Harnett County Department of Public Health Improvement Permit

*Revised to remove
Pump tank IF
Plumber can Achieve
Fall*

PROPERTY LOCATION: 400 Clark Rd (SR 1129)

Application # EH2307-0001

## Harnett County Department of Public Health Site Sketch

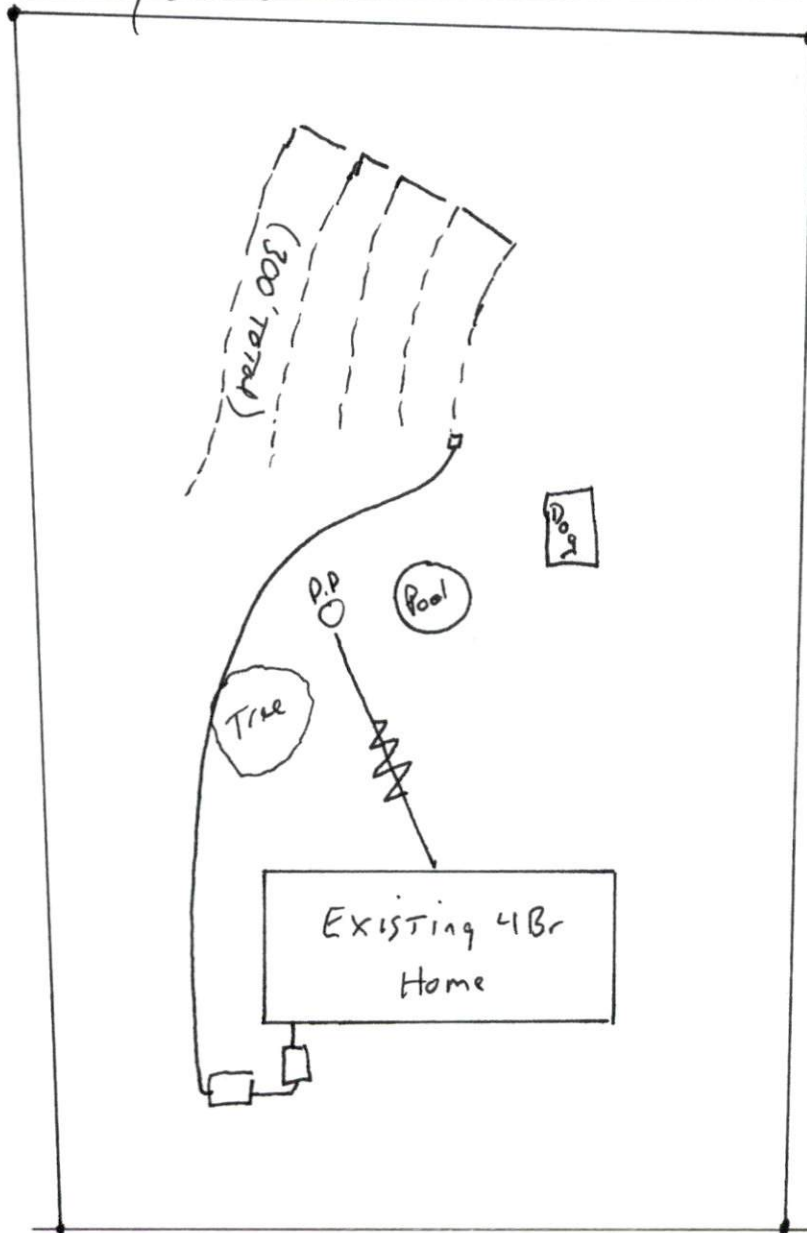
* will need to re-plumb house to get fall to new septic tank behind house and from tank to drain line.

Conditions: Will need to re-plumb the house to get fall into the septic tank, and then to the drain field
